ENG-CDR21013-R3-CDs.pdf Markup Summary

**STERLING RANCH DEVELOPMENT
BRIARGATE BOULEVARD BRIDGE CONSTRUCTION DRAWINGS
STRUCTURE LAYOUT**
EL PASO COUNTY, COLORADO

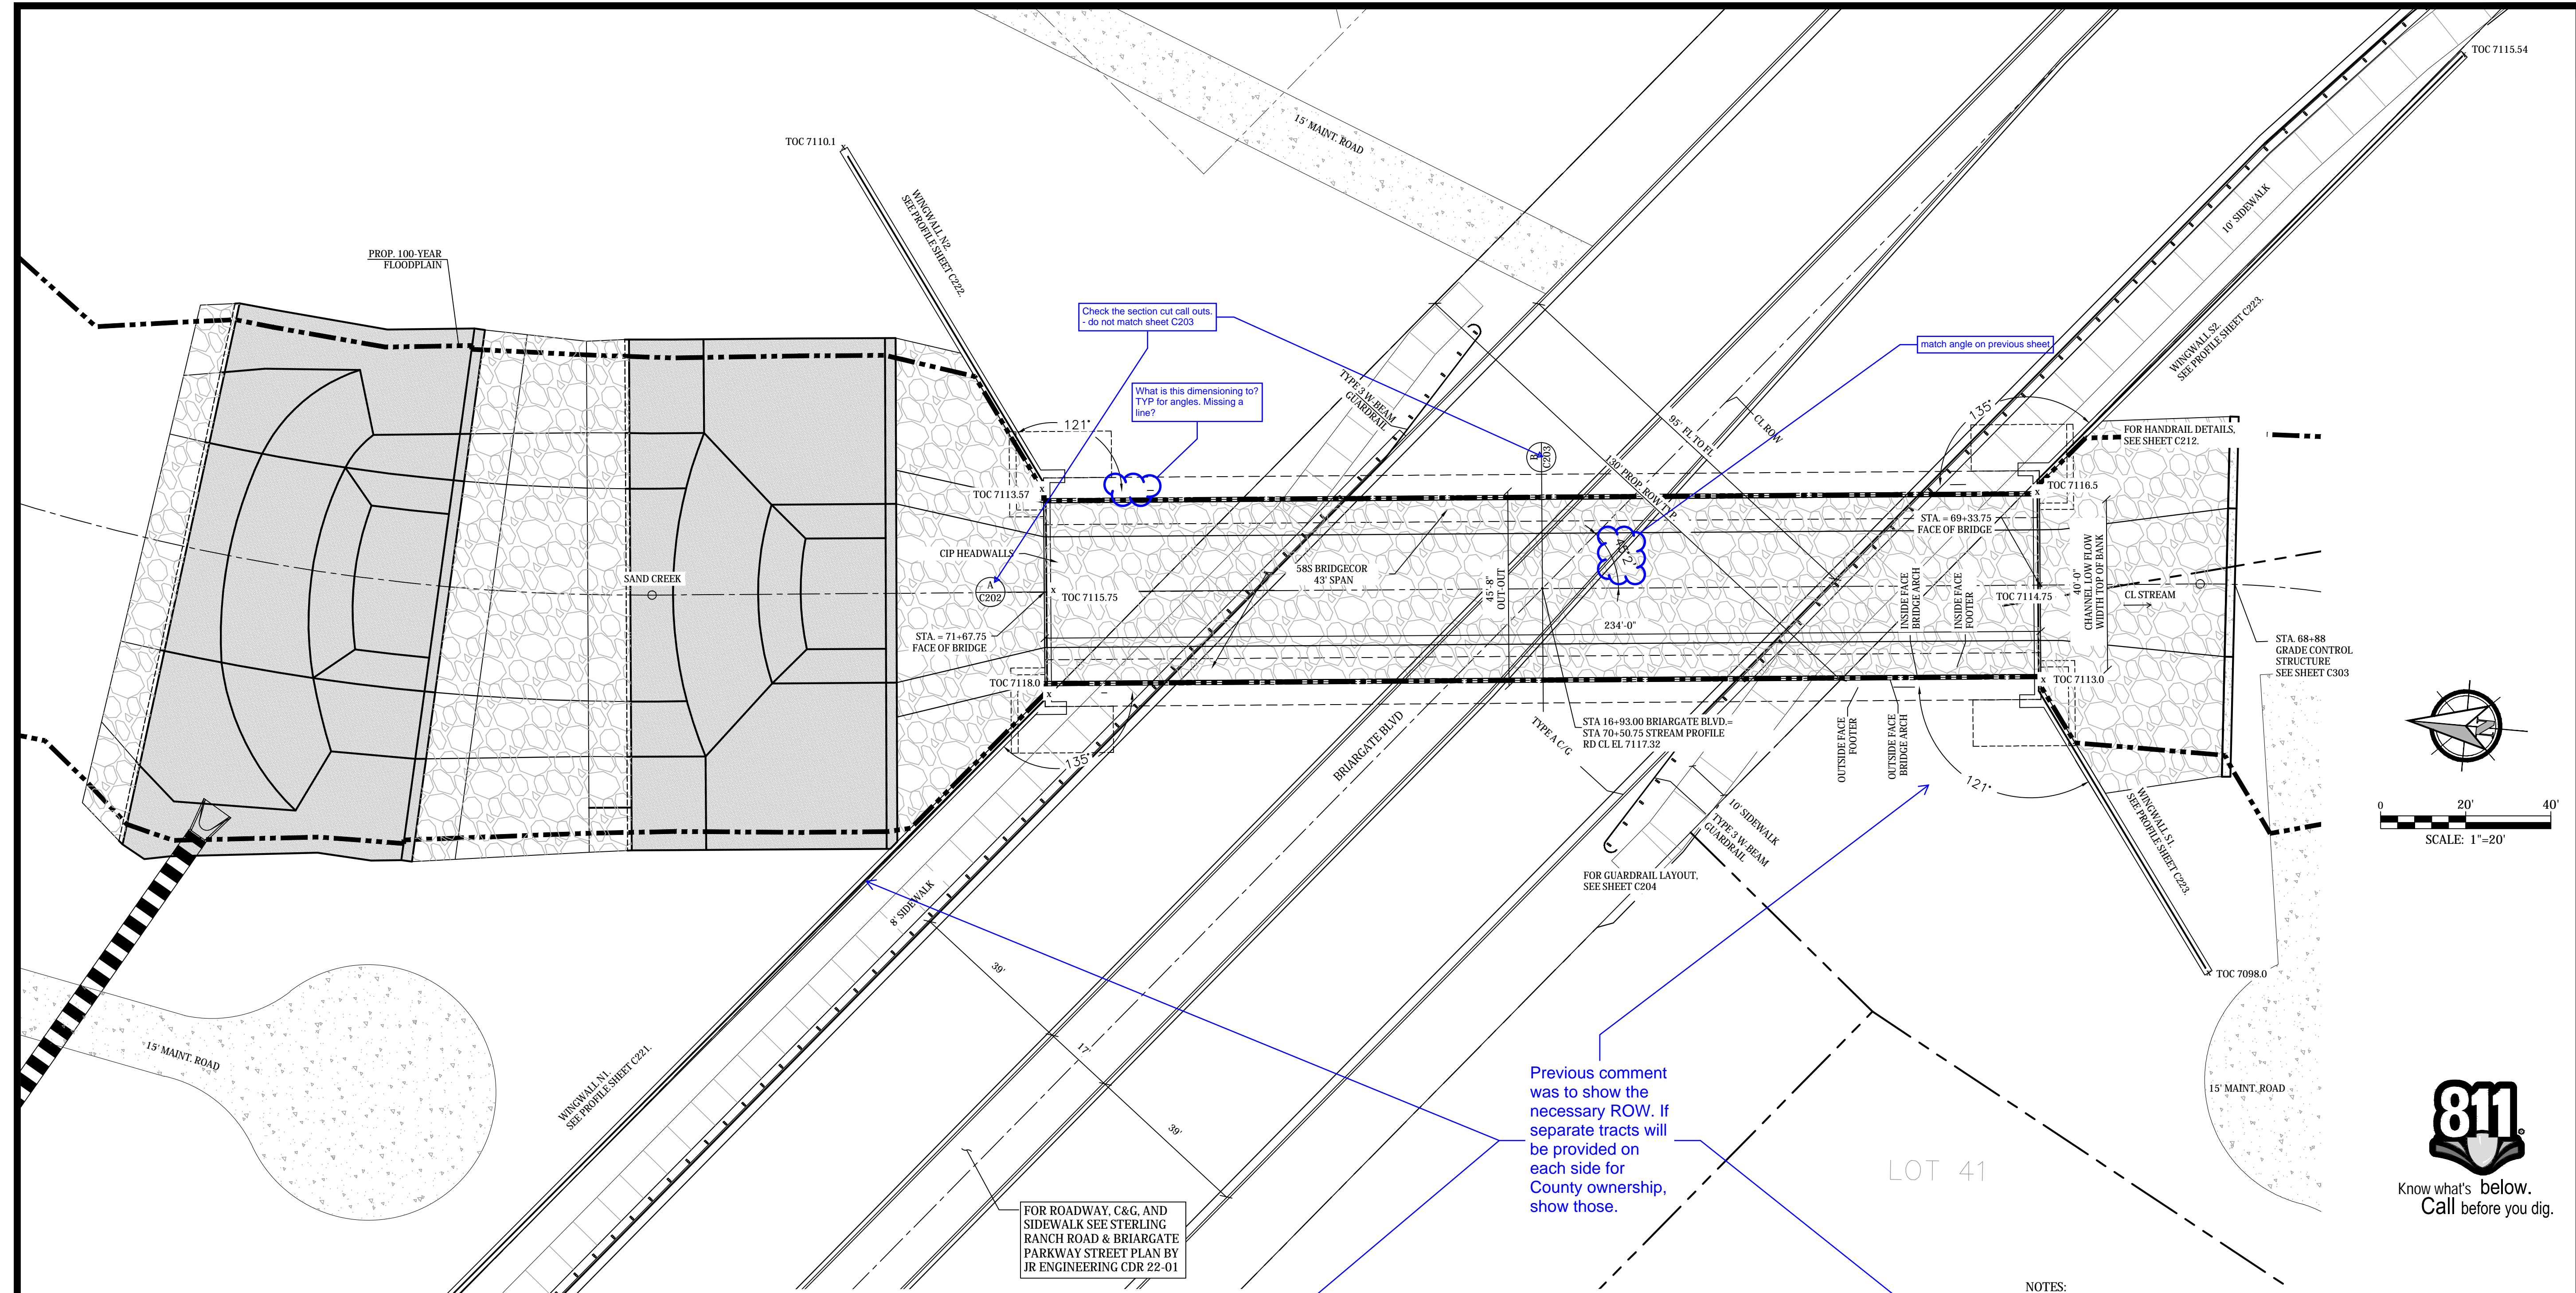
Check the section cut call outs. - do not match sheet C203

WINGWALL N1 PLAN
1"=10'

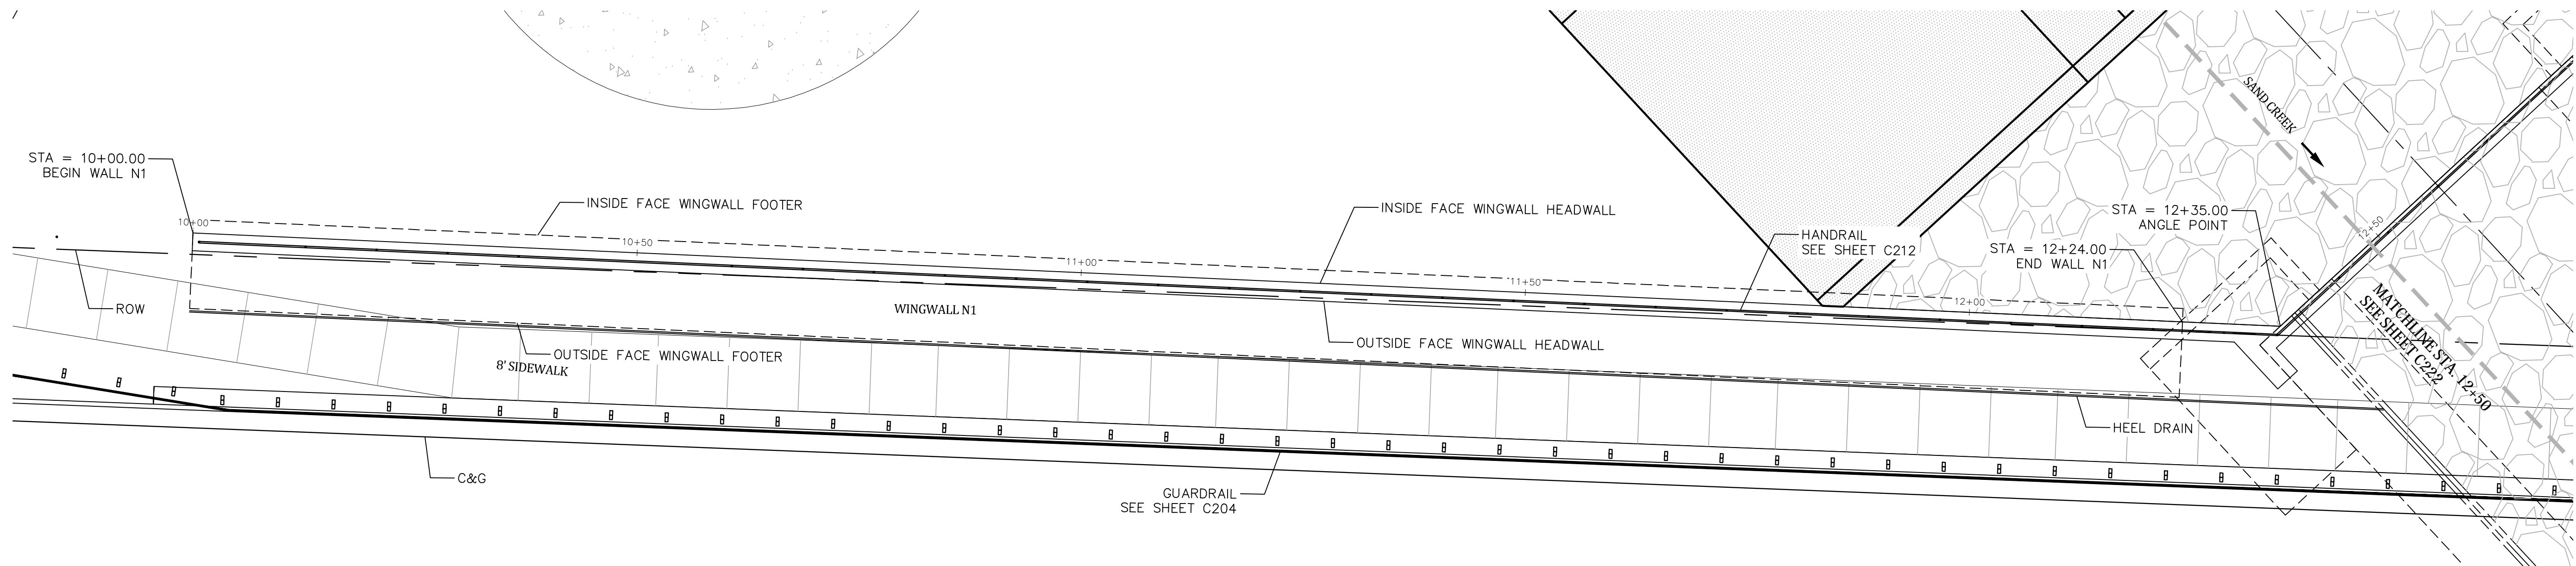
Please lighten the grid

WINGWALL N1 PROFILE

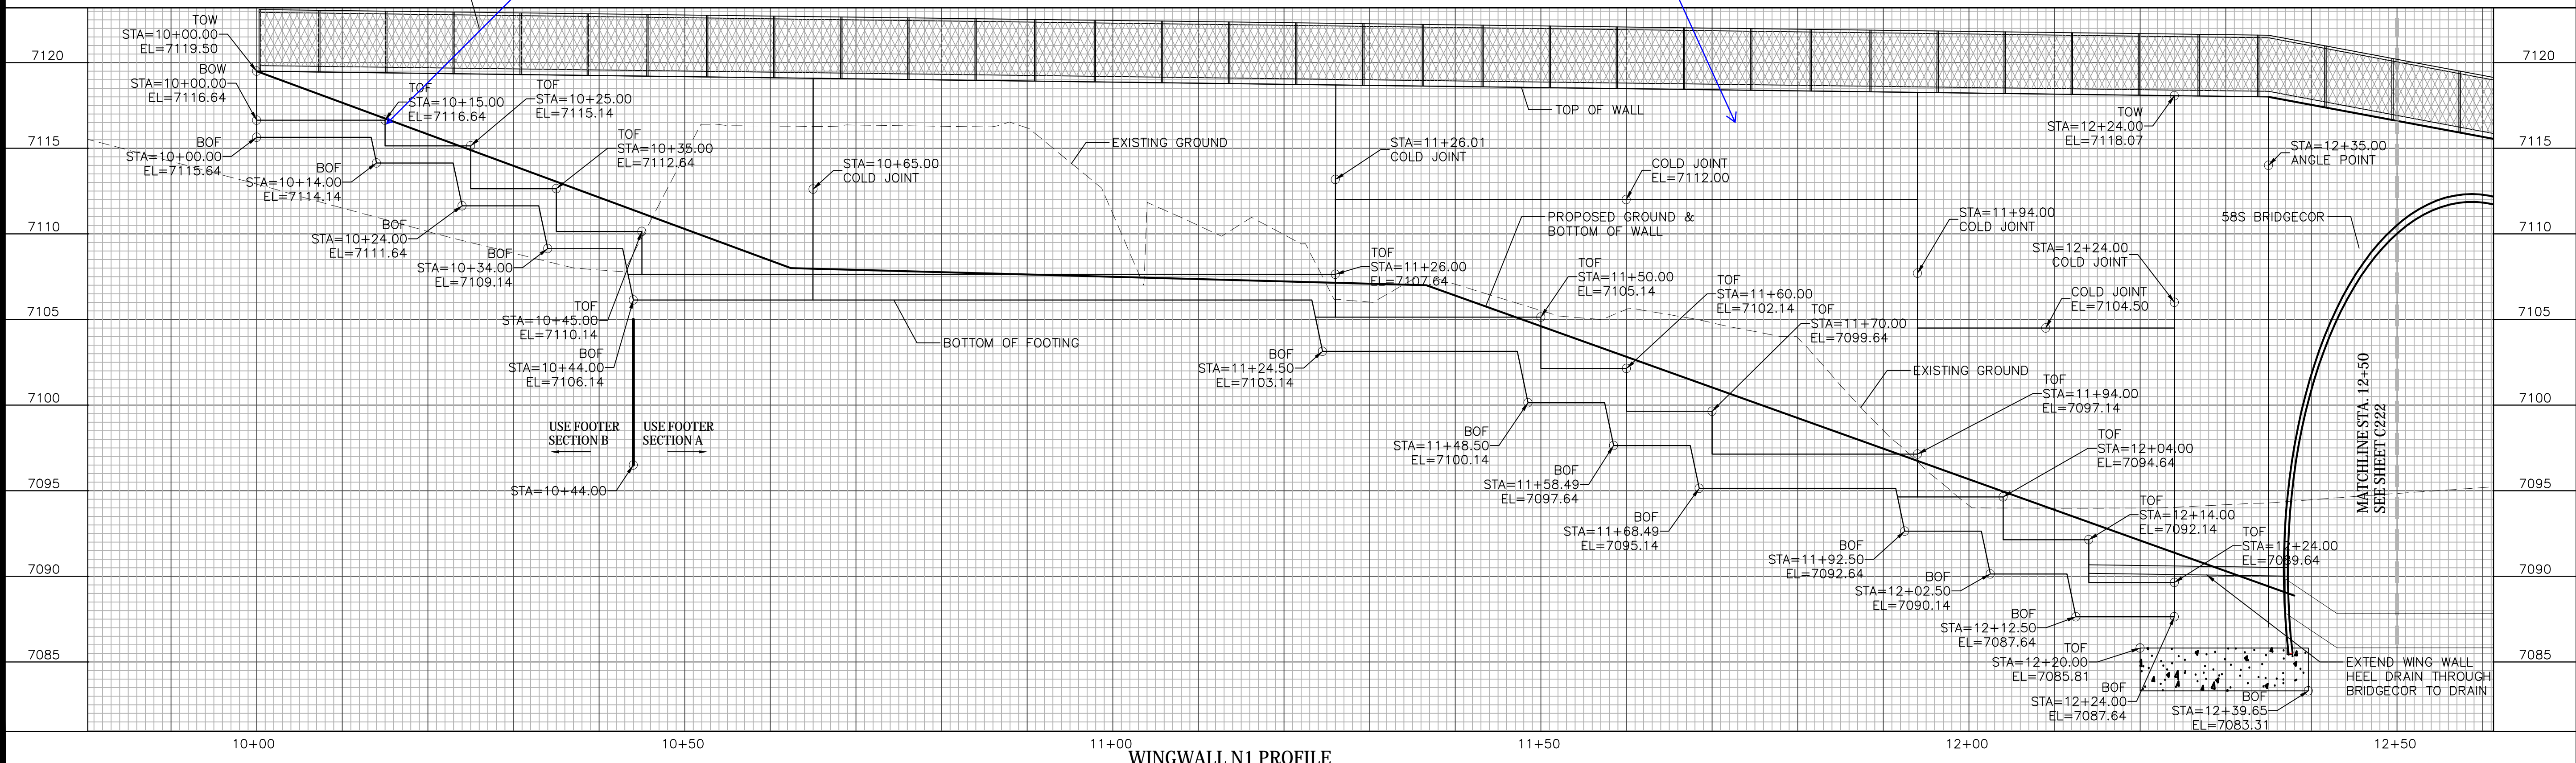
confirm that footing base is 36" below finished grade for frost protection in all locations (ref geotech report).

C222

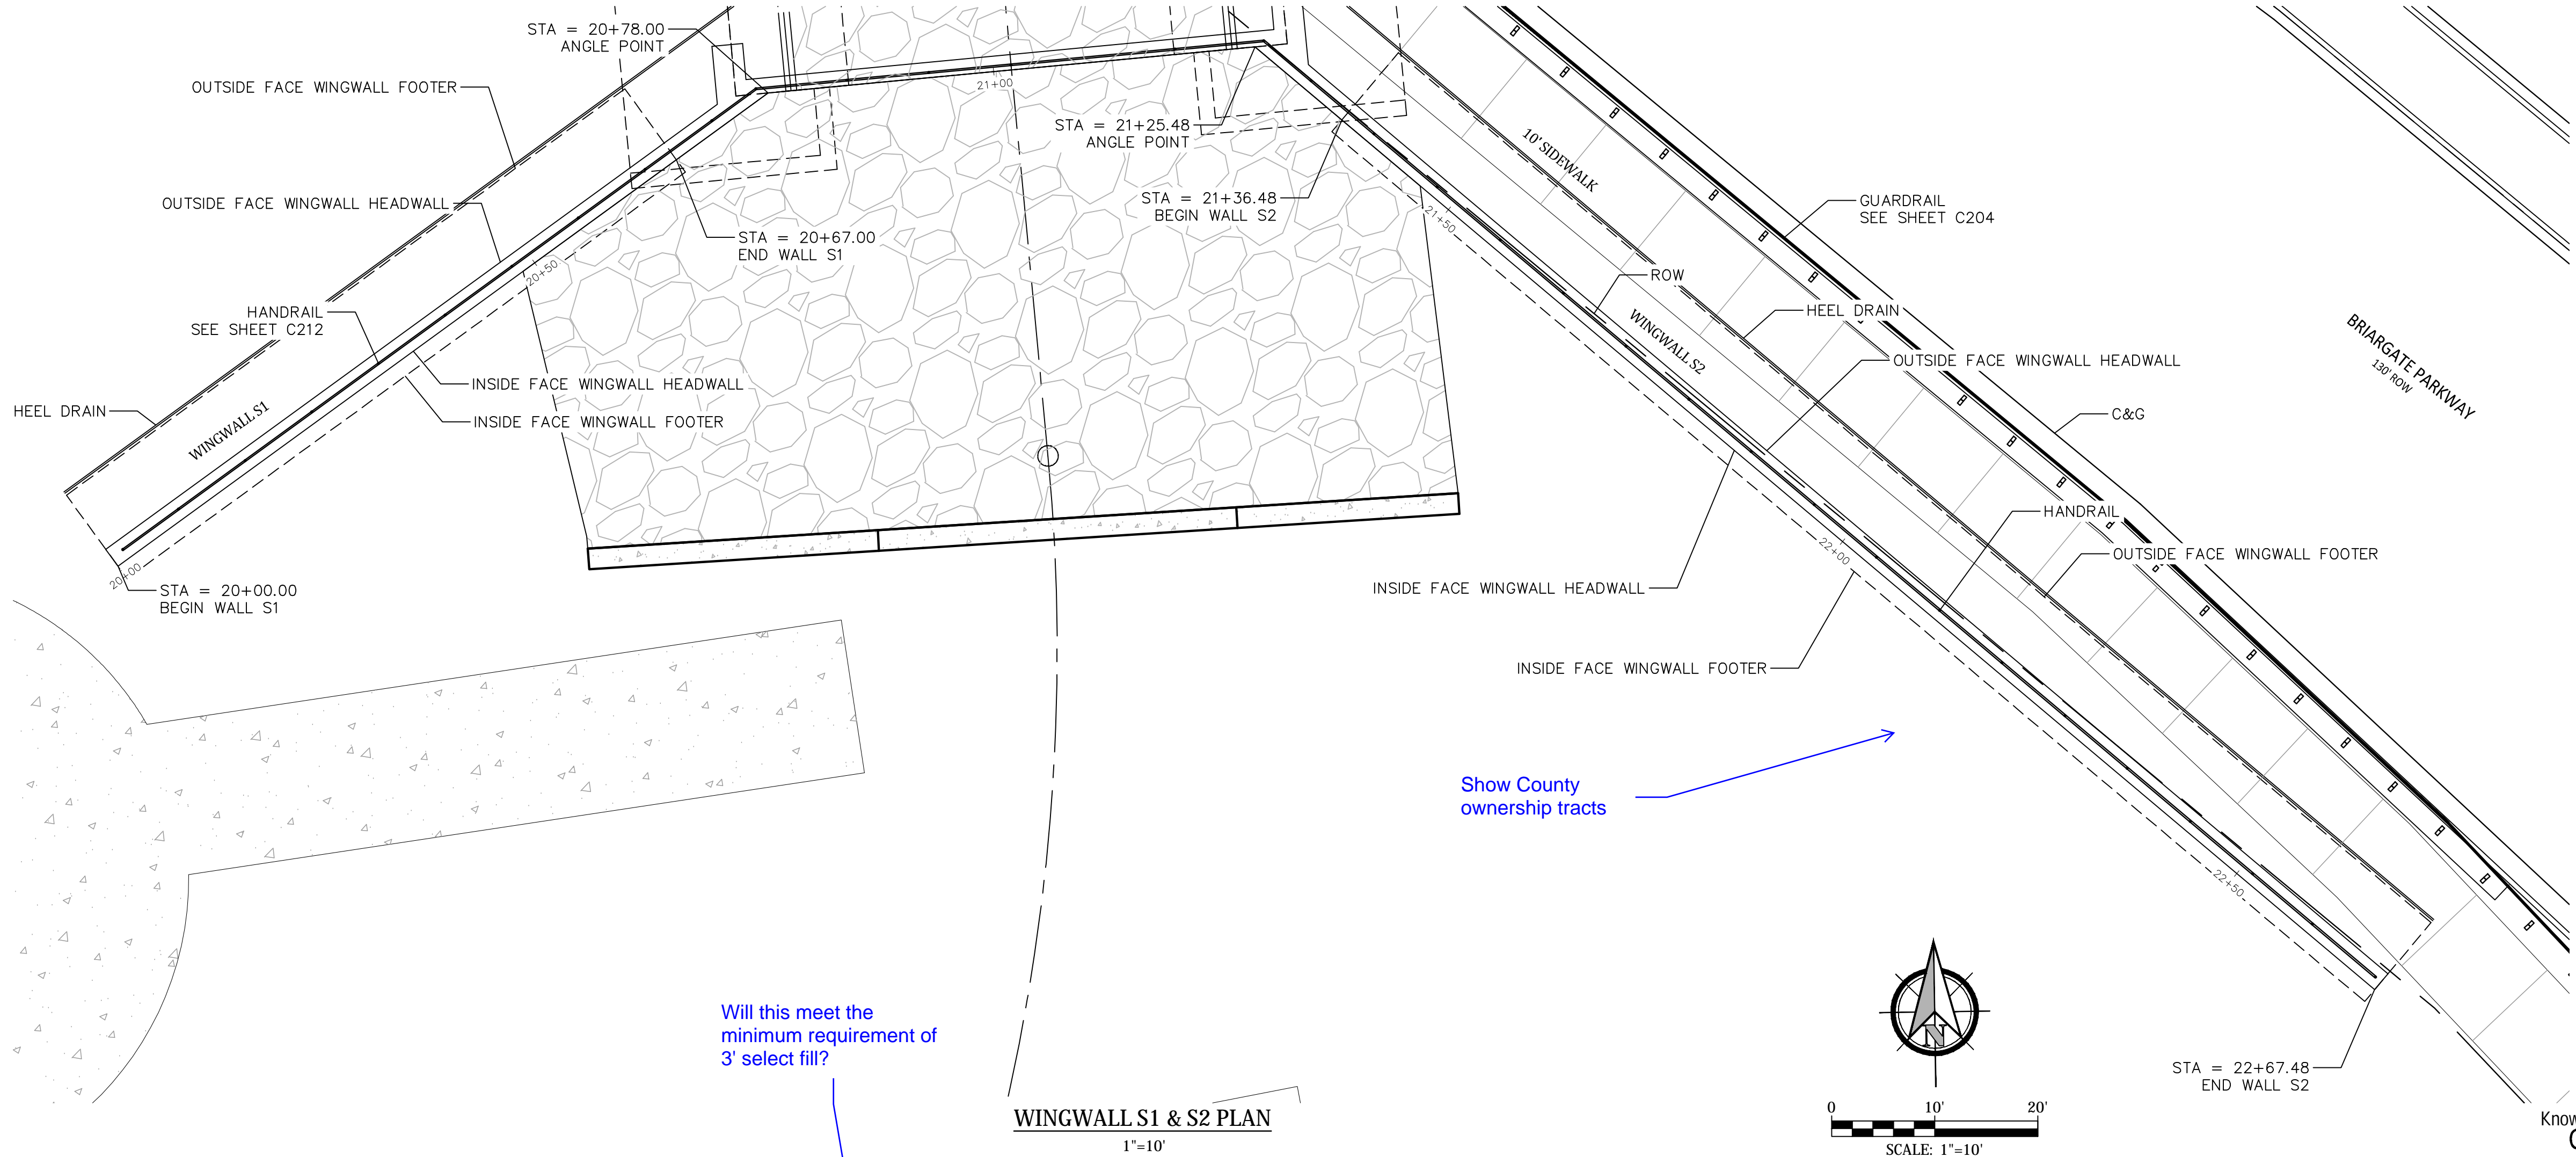
Will this meet the minimum requirement of 3' select fill?

BRIDGE FOOTING PROFILE

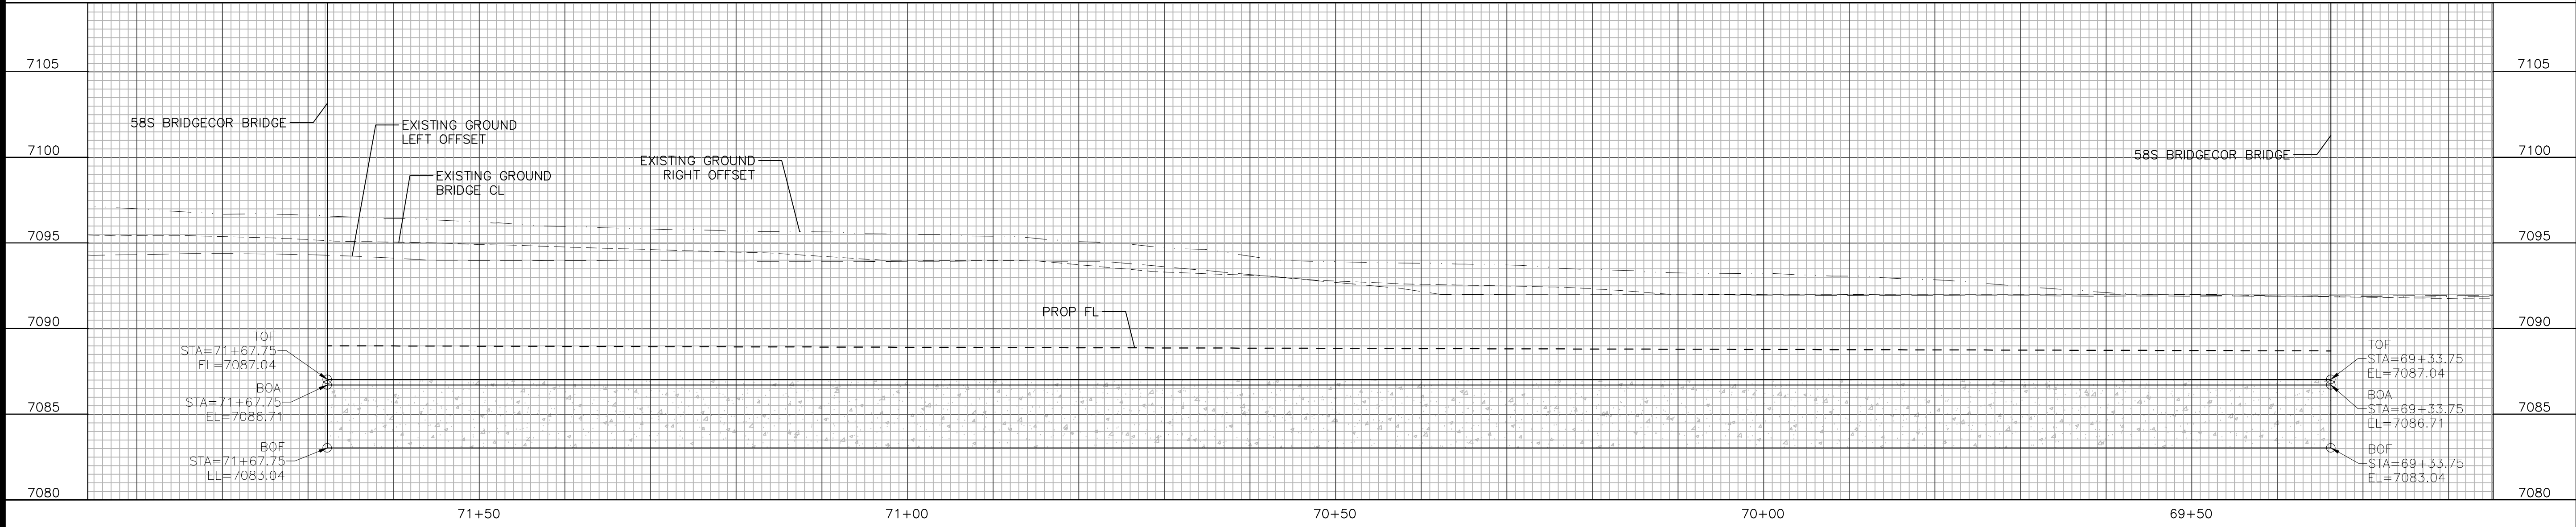
Add notes regarding the required geotech testing upon excavation and required placement of footings on sandstone if that is the case per footing design report.
